CITY OF PORTLAND

Job ID: 2011-10-2383-FAFS

has permission to install master box fire alarm system

Job ID: 2011-10-2383-FAFS
Installation of master box fire alarm system

GRAPHIC DISPLAY MAP

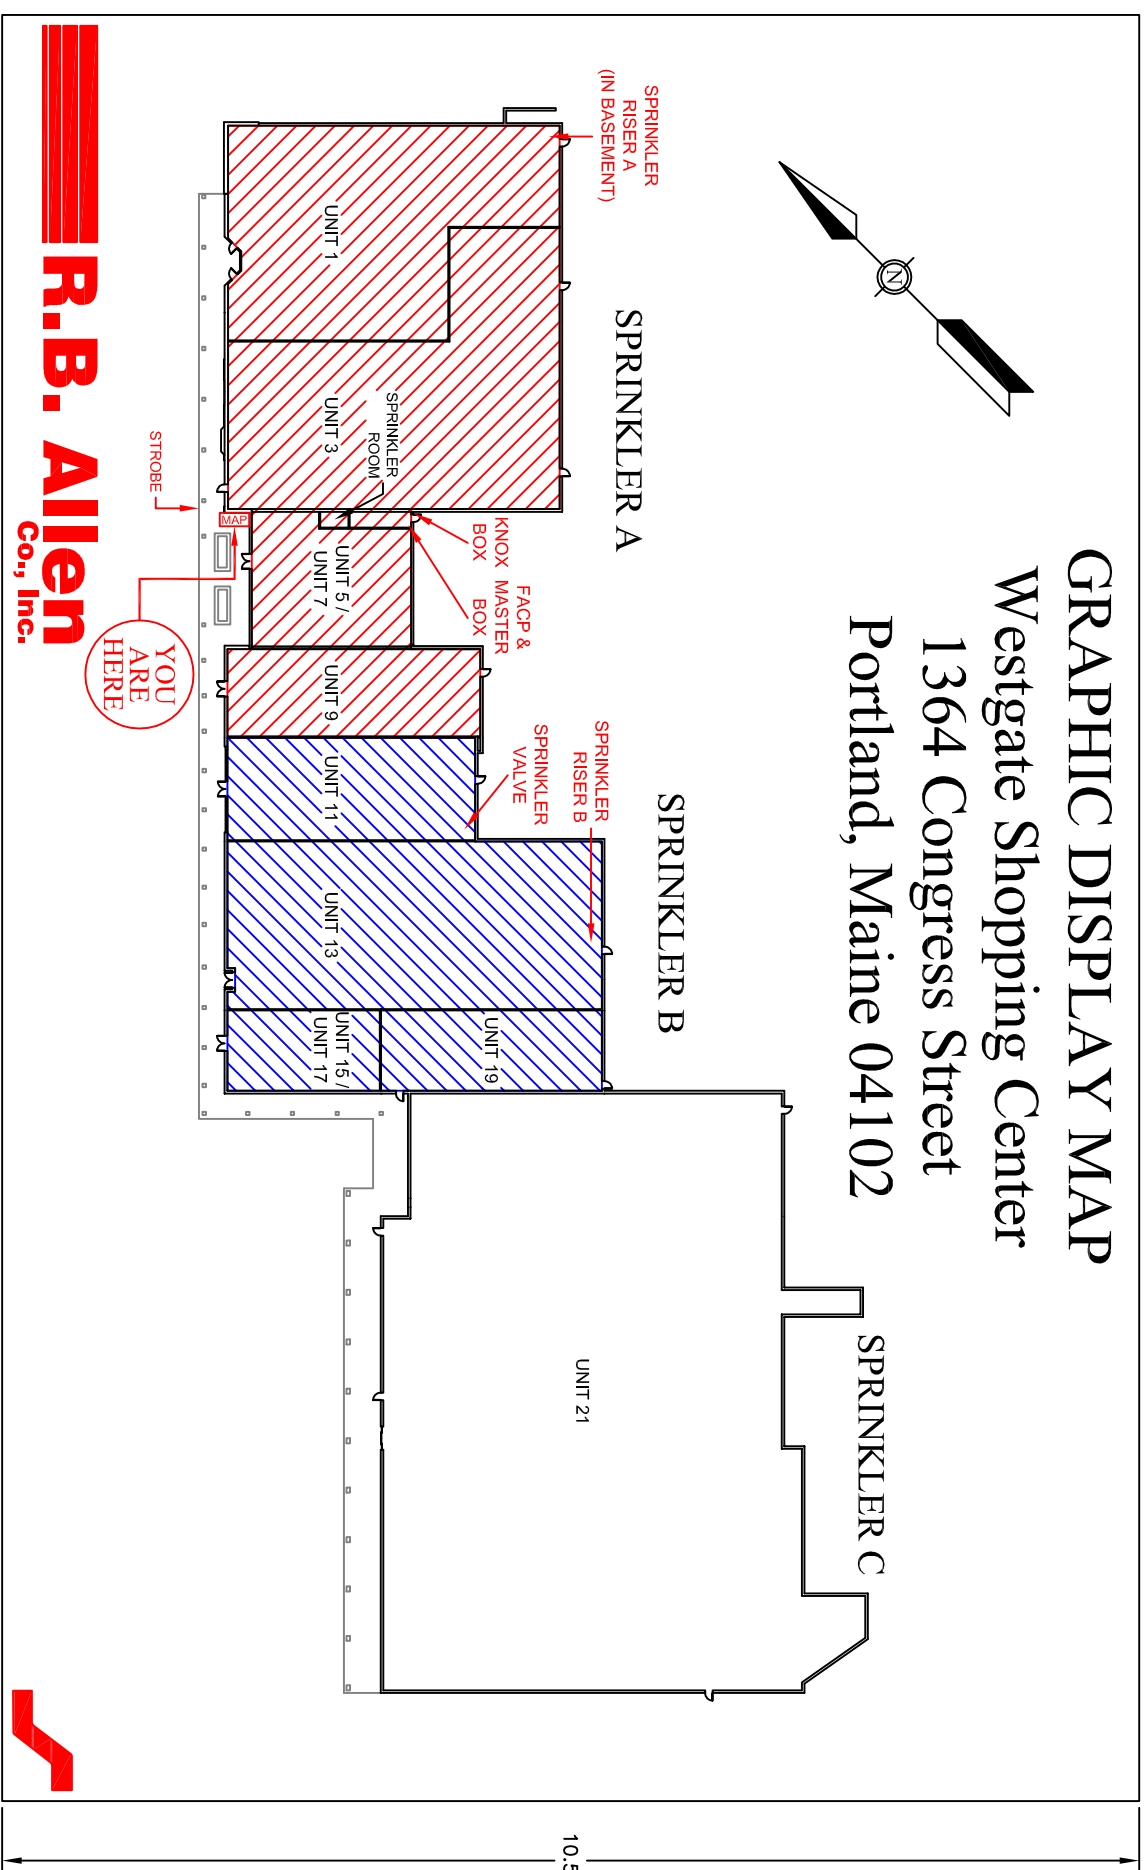
A graphic map shall be provided over the annunciator depicting suite letters, location of the FACP, and the sprinkler risers. These suite letters shall be used to annunciate non water flow alarms.

Each annunciator zone shall indicate only one tenant alarm and each sprinkler water flow shall be separately annunciated.
